TIP PROJECT: BR-0127

UTILITIES BY OTHERS PLANS YADKIN COUNTY

LOCATION: BRIDGE NO. 980189 OVER UT OF SOUTH DEEP CREEK ON SR 1325 (MOUNTAIN VIEW CHURCH ROAD)
 TYPE OF WORK: GRADING, DRAINAGE, PAVING, AND STRUCTURE

Drawing file: 290 Utility by Others Plans / 290_002_BR-0127_ Final UBO_UO-4.pdf

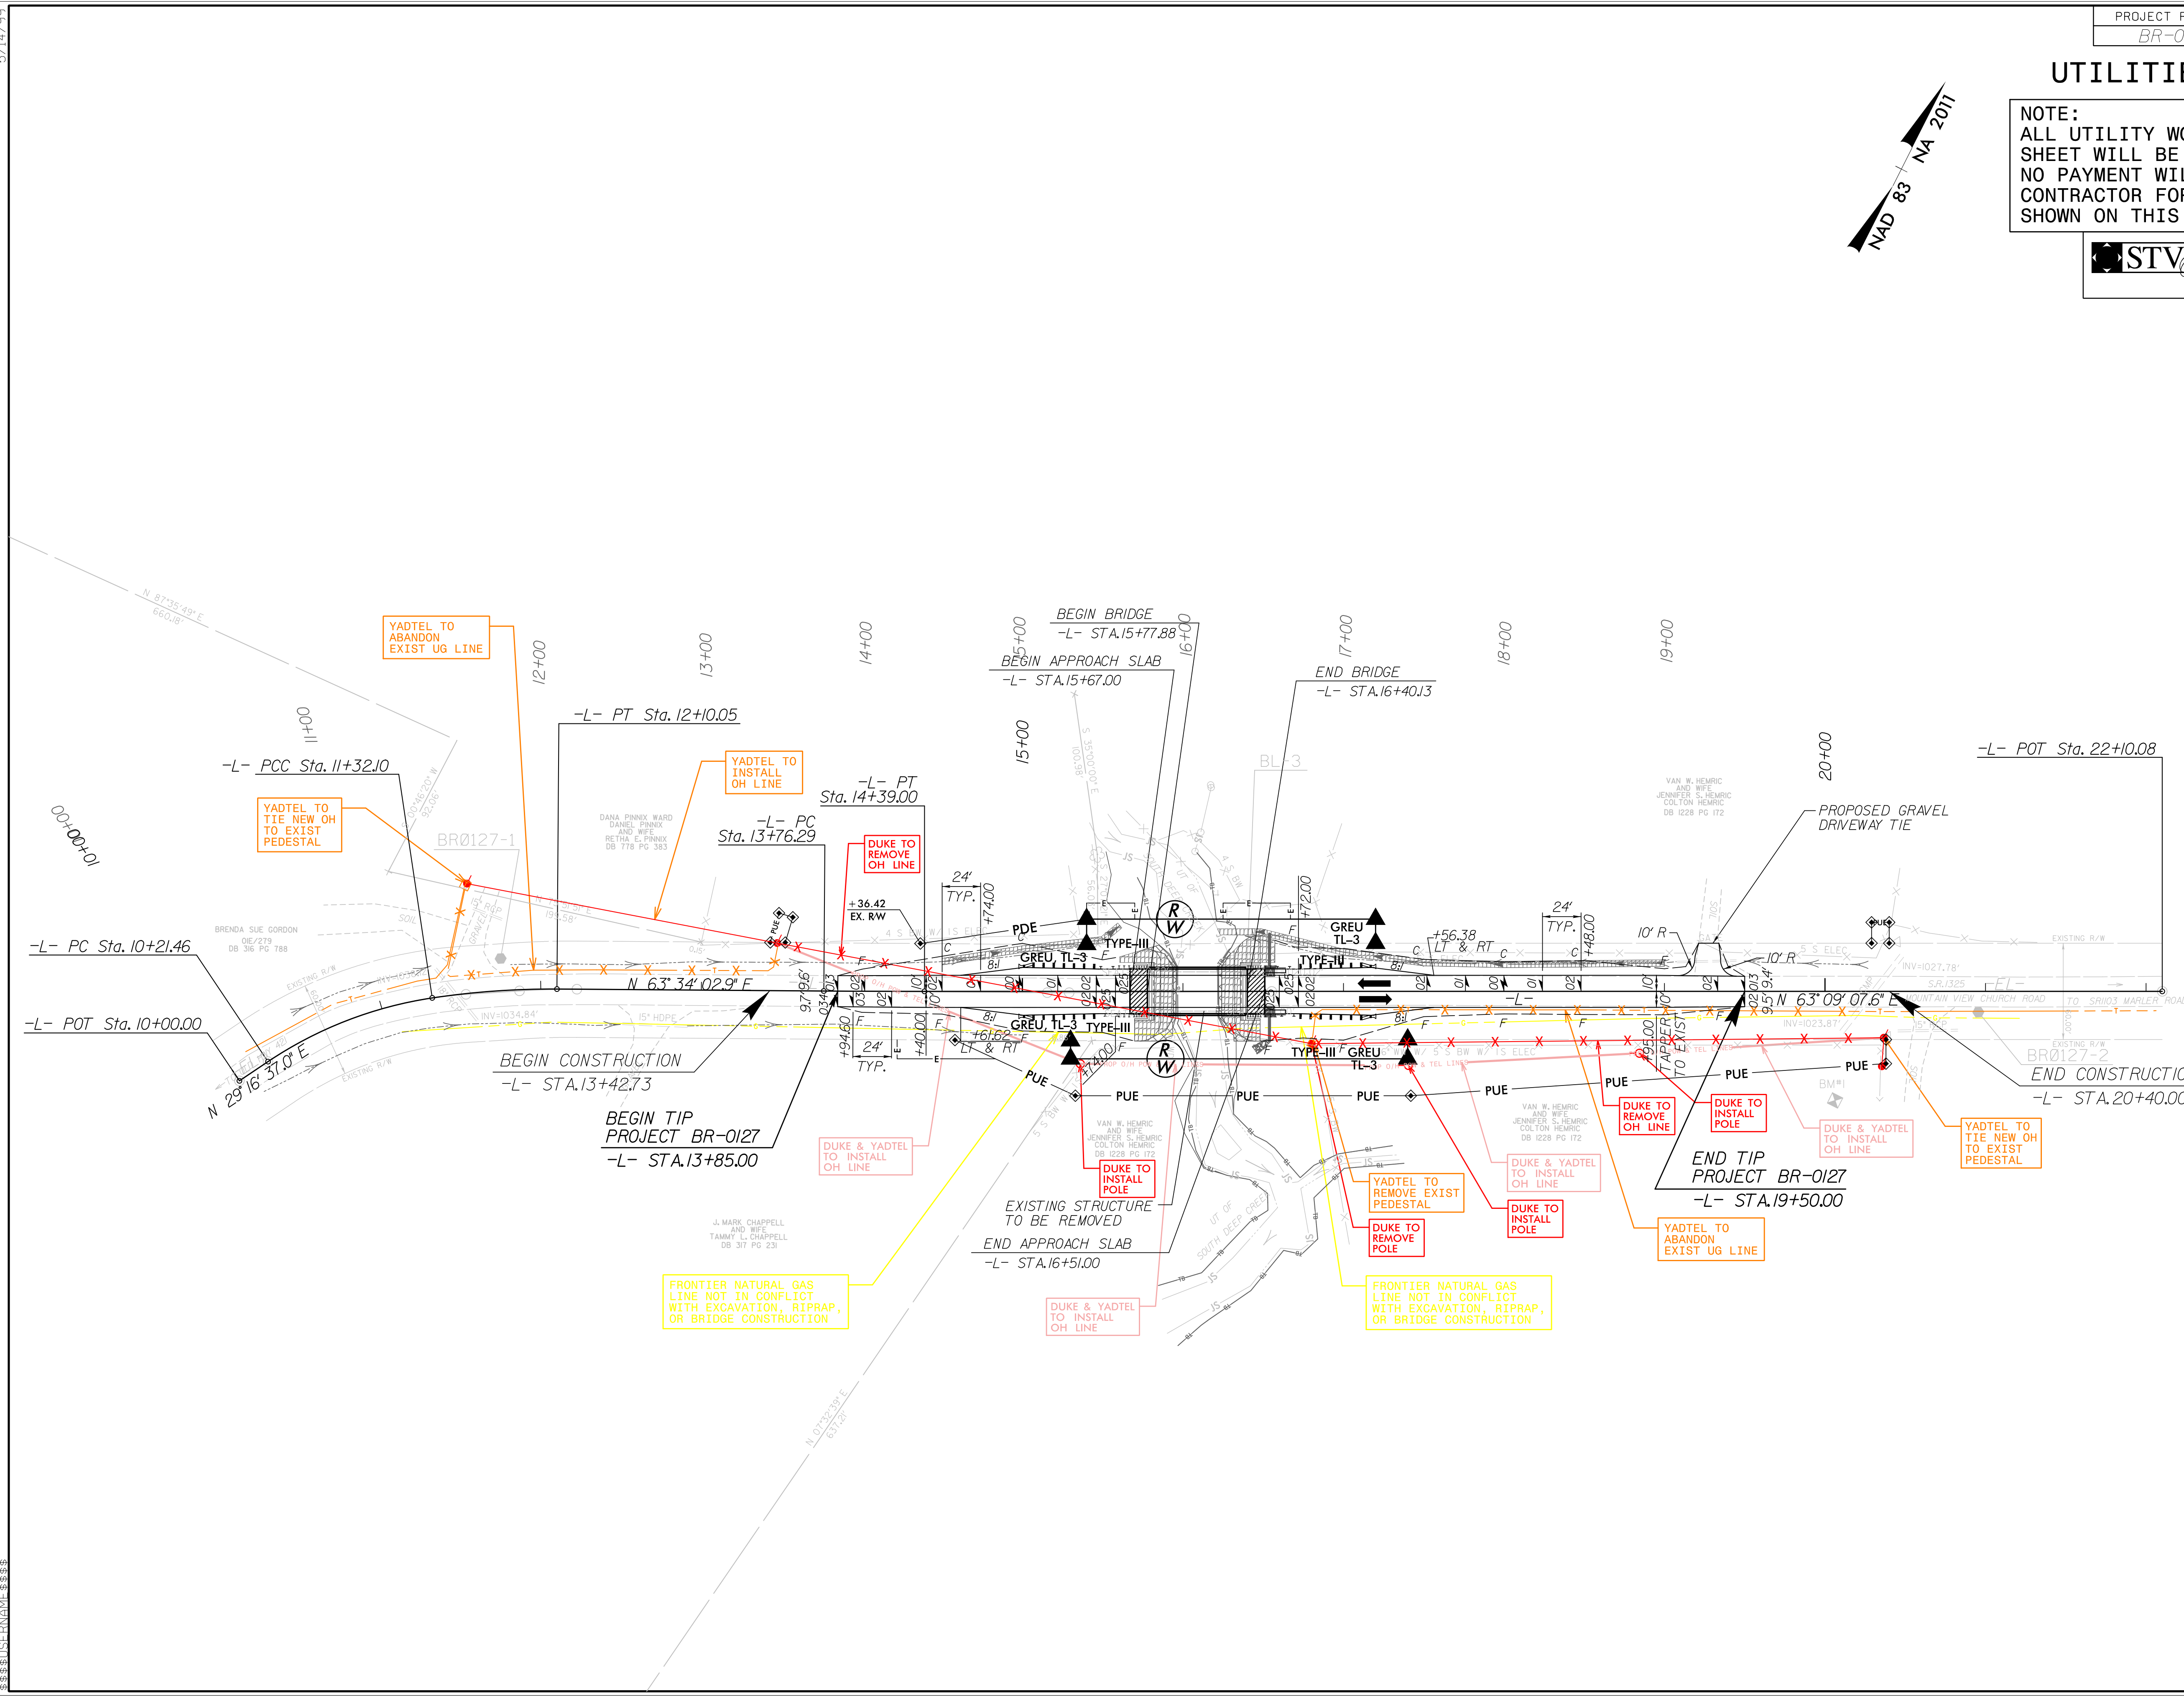
FRONTIER NATURAL GAS LINE NOT IN CONFLICT WITH EXCAVATION, RIPRAP, OR BRIDGE CONSTRUCTION

FRONTIER NATURAL GAS LINE NOT IN CONFLICT WITH EXCAVATION, RIPRAP, OR BRIDGE CONSTRUCTION

I understand that the lines shown on these plans are not level B SUE and are drawn in by record, not by field locates. I concur that with the depths provided by us, Frontier Natural Gas, our lines are not in conflict with this project. I agree with all notes and markups made on this sheet.
